26 April 2022

**Subject:** *Submission to SSD-10387 – Daroobalgie Solar Farm*

**Reference:** *SSD-10387*

DAROOBALGIE SOLAR ROAD DESIGN
GENERAL ARRANGEMENT
SHEET 2

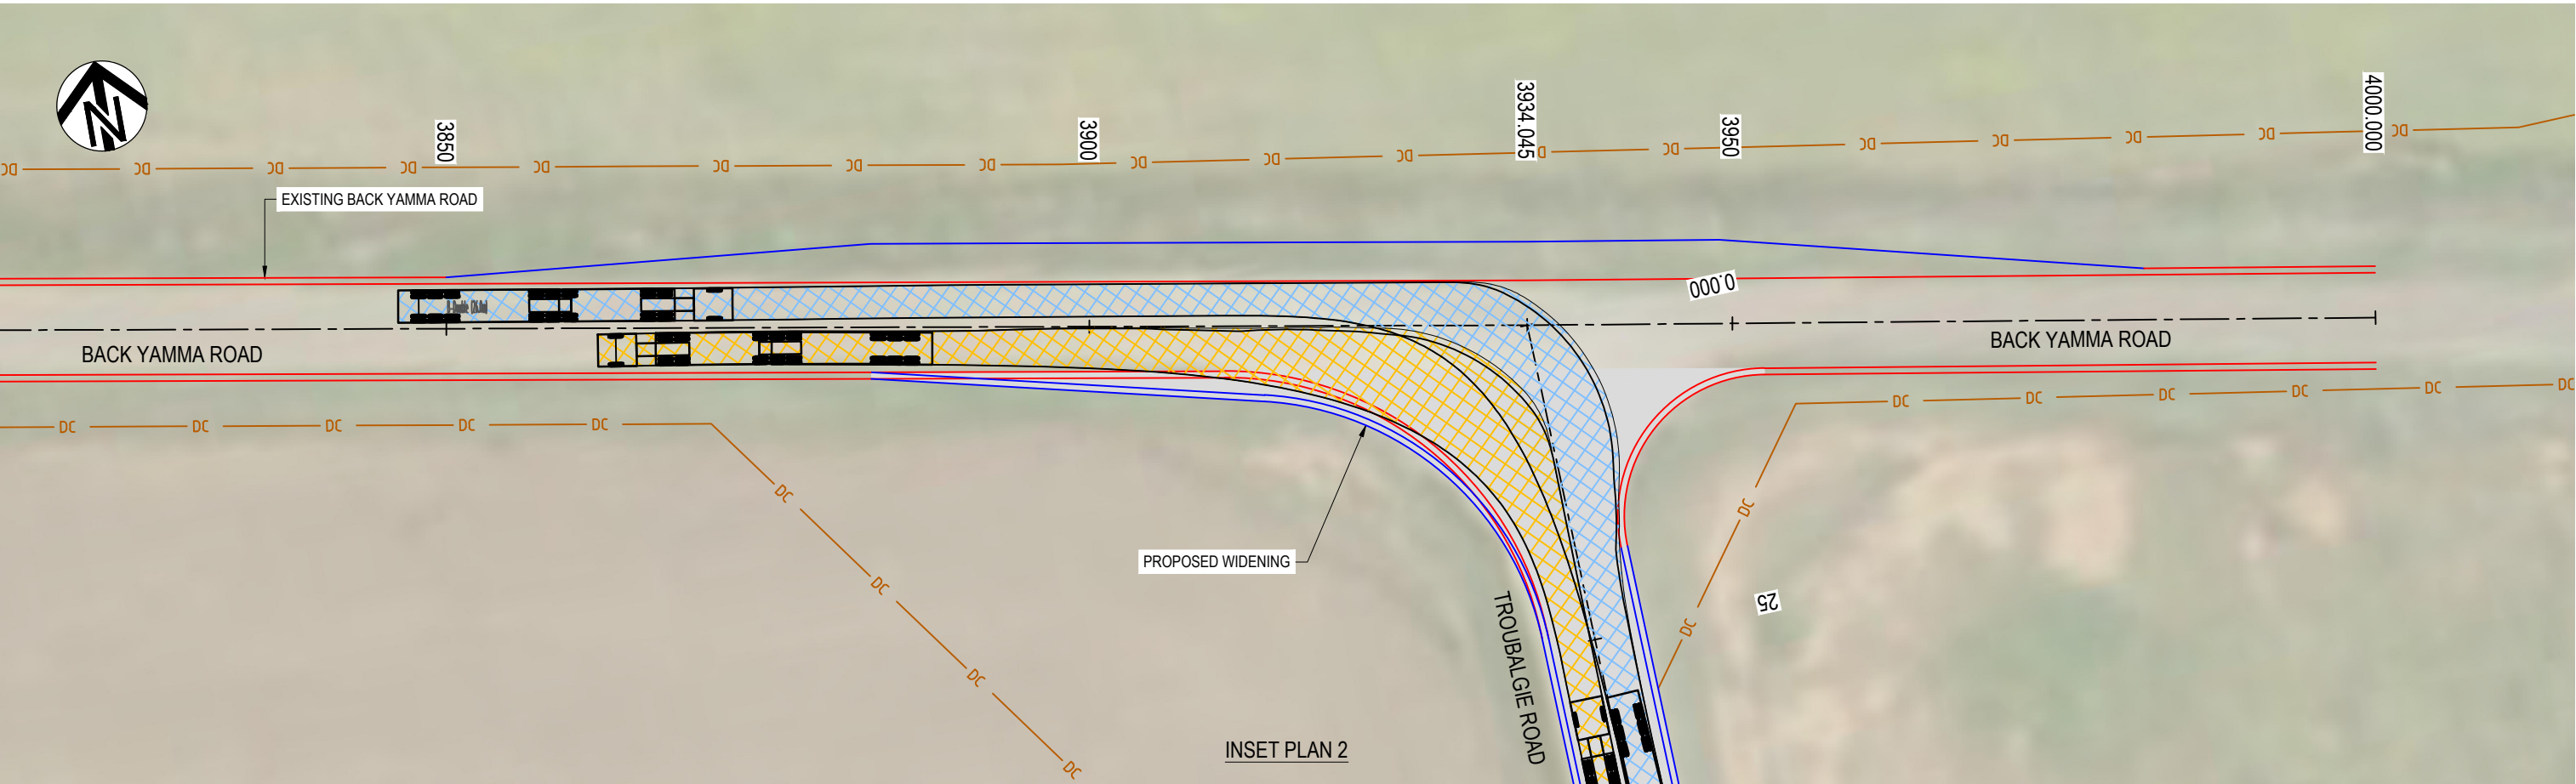
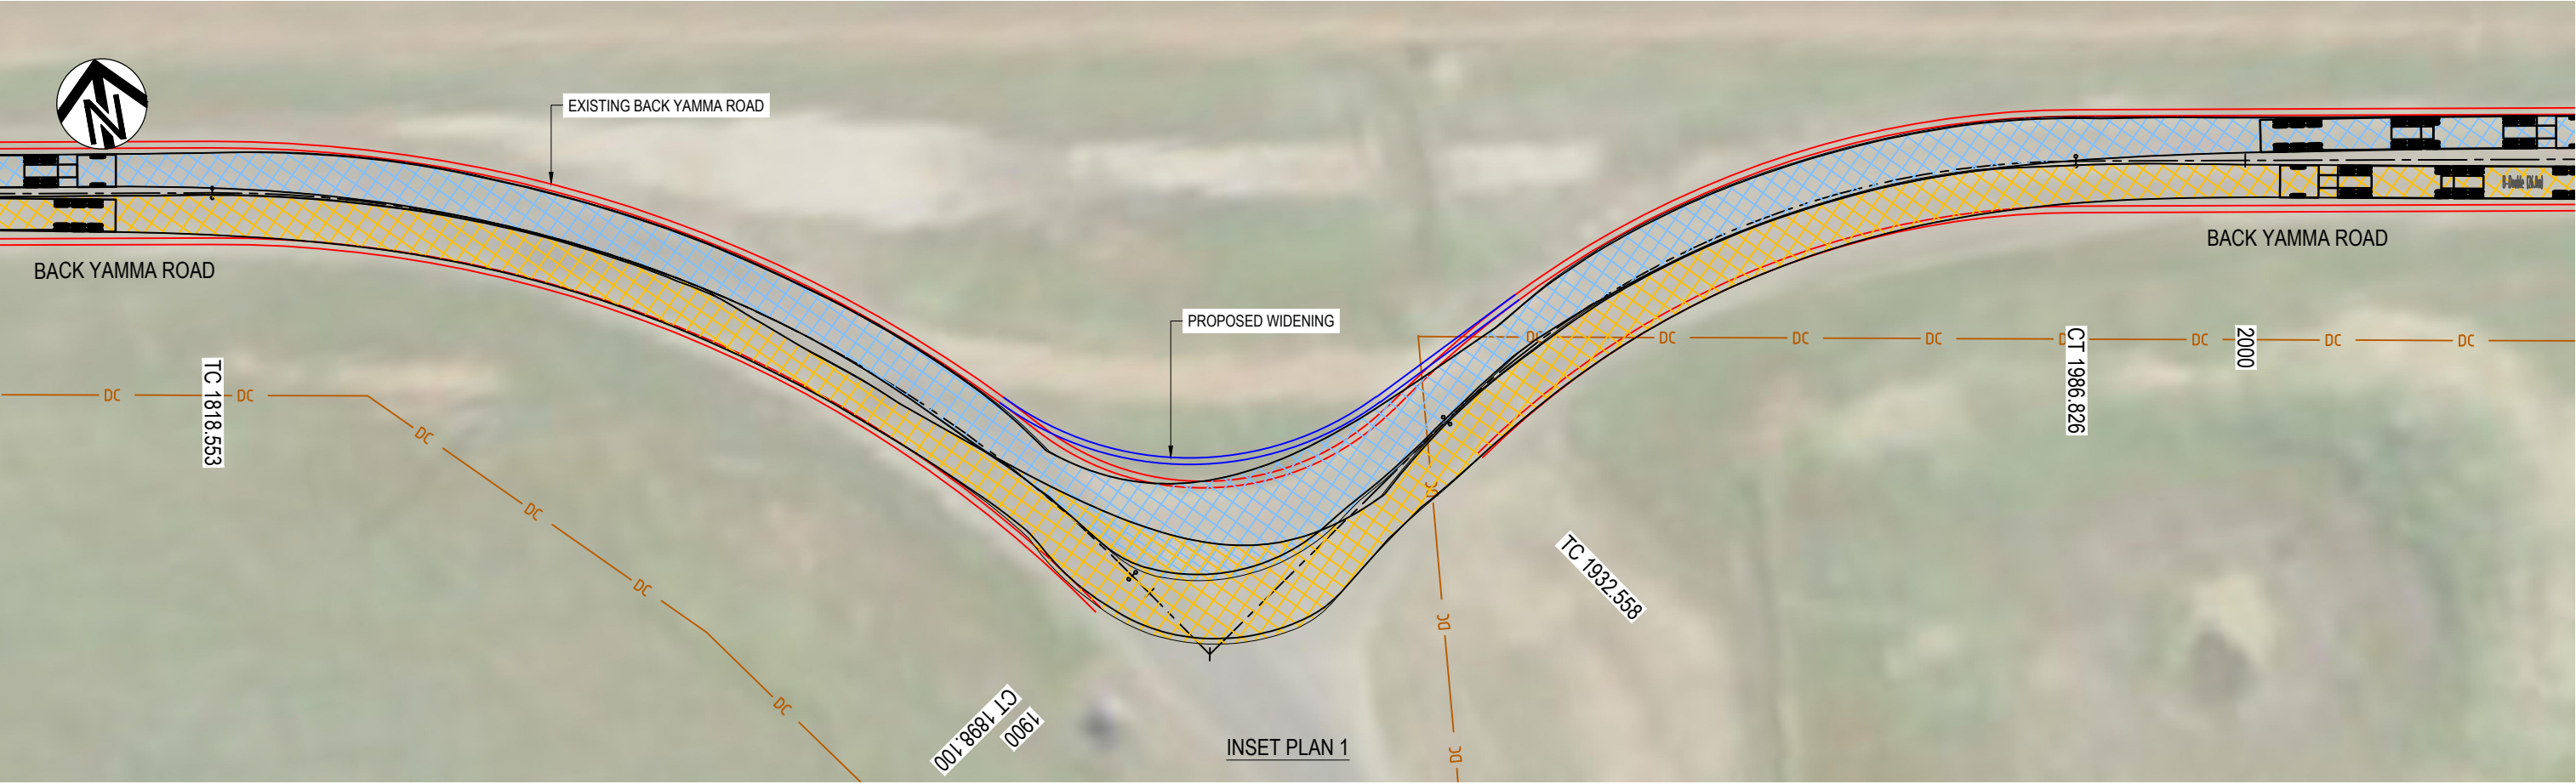
Council supports the Applicant's proposal to seal Troubalgie Road from Back Yamma Road to the access location of the development site and requires this be a condition of consent. This work and design is subject to approval by Council in accordance with Section 138 of the *Roads Act 1993*, and is to be conditioned as such.

DAROOBALGIE SOLAR ROAD DESIGN
INTERSECTION LAYOUT AND
TURNPATHS - SHEET 1

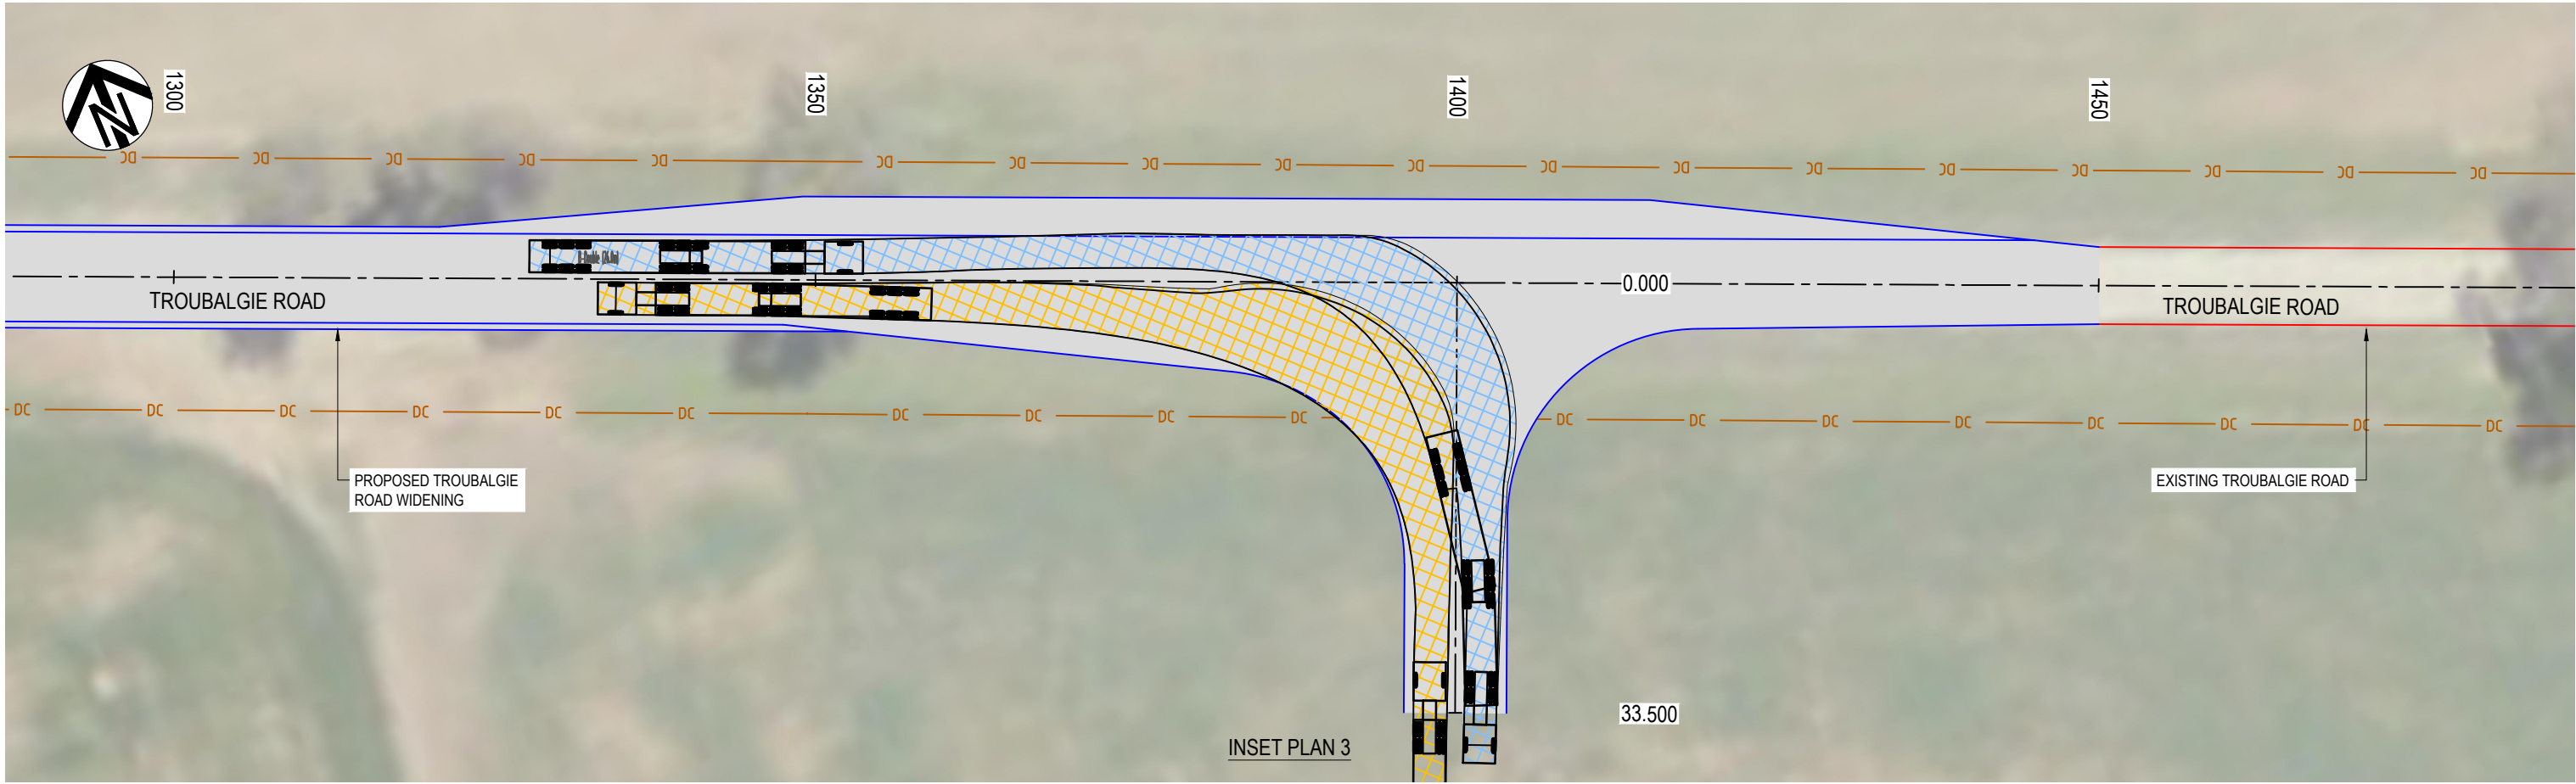
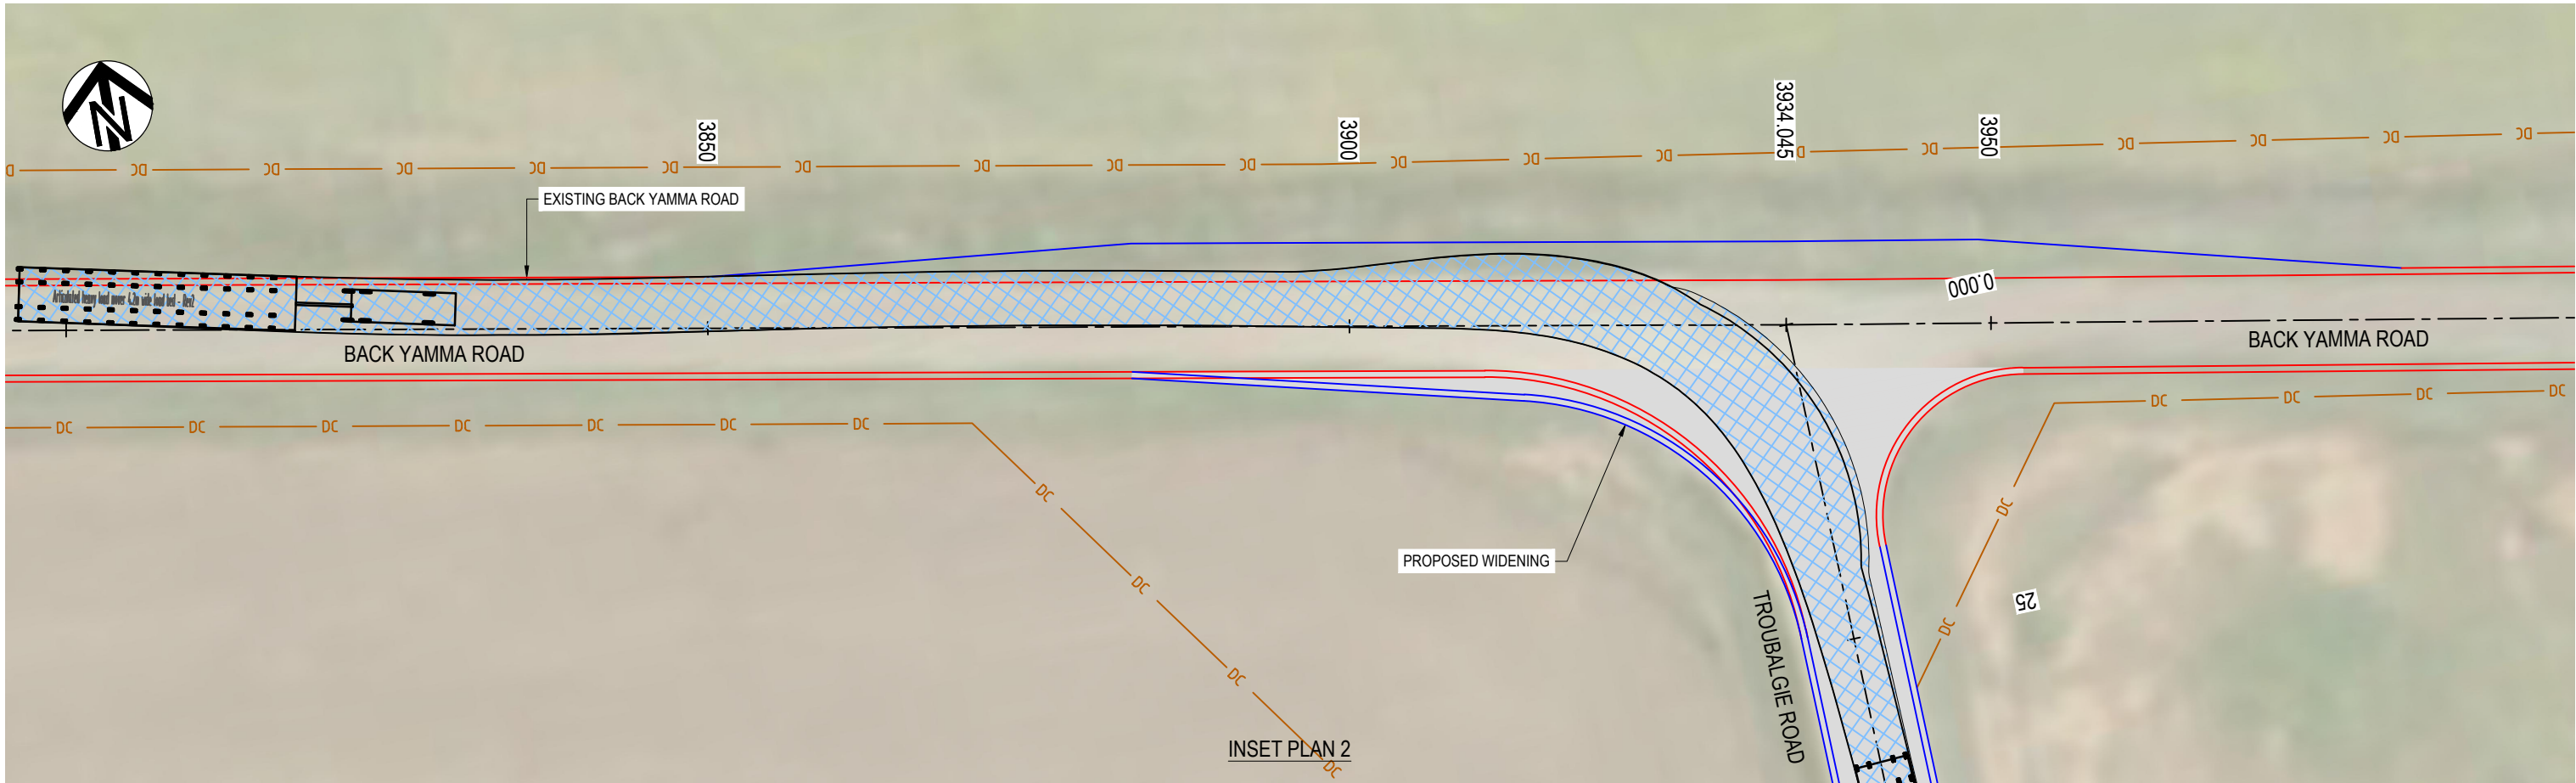
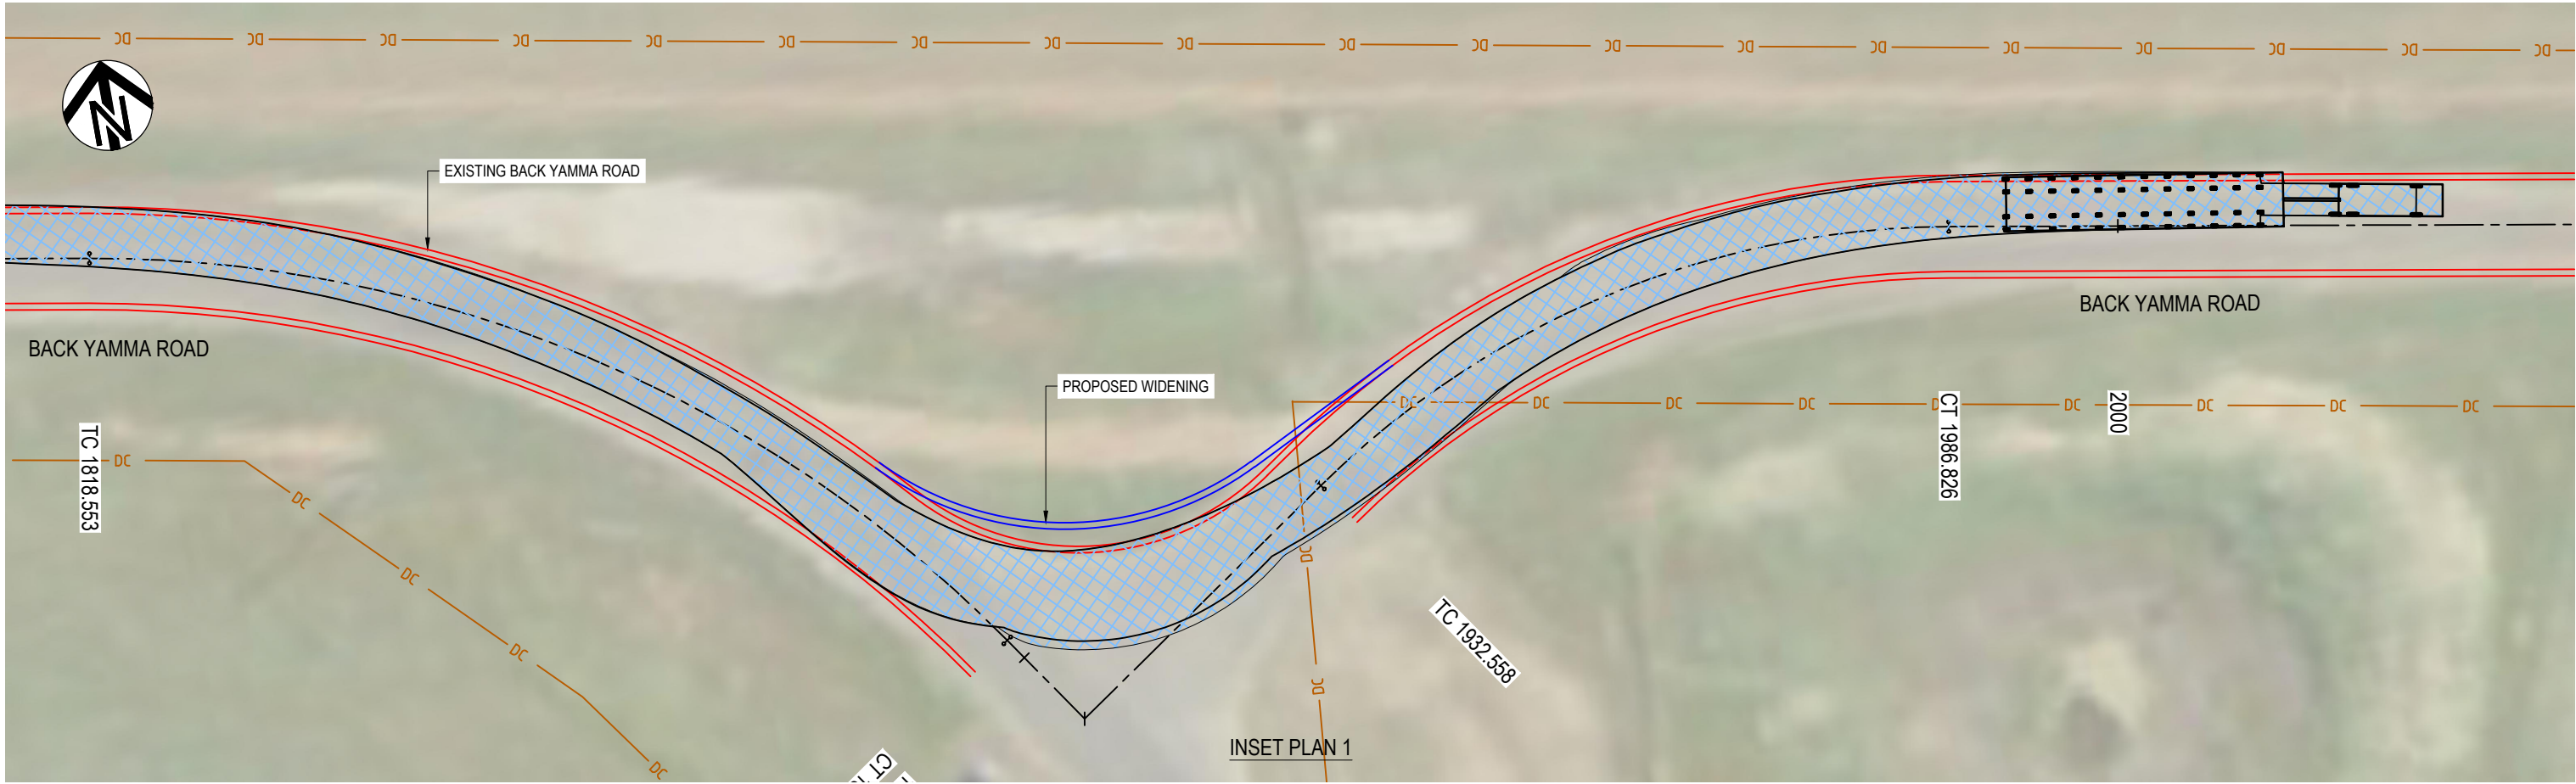
Council supports the Applicant's proposal to upgrade the Back Yamma Road and Troubalgie Road intersection. This upgrade must be a condition of consent. Council considers it necessary that this intersection be upgraded to a Basic Left/Basic Right intersection arrangement in accordance with *Austroads Guide to Road Design* and designed to accommodate the turning paths of the largest vehicle. This work and design is subject to approval by Council in accordance with Section 138 of the *Roads Act 1993*, and is to be conditioned as such.

Council requests that the intersection access to the project site is designed as a Basic Left/Basic Right intersection treatment in accordance with *Austrroads Guide to Road Design*. This is to be a condition of consent and the design subject to approval by Council in accordance with Section 138 of the *Roads Act 1993*.
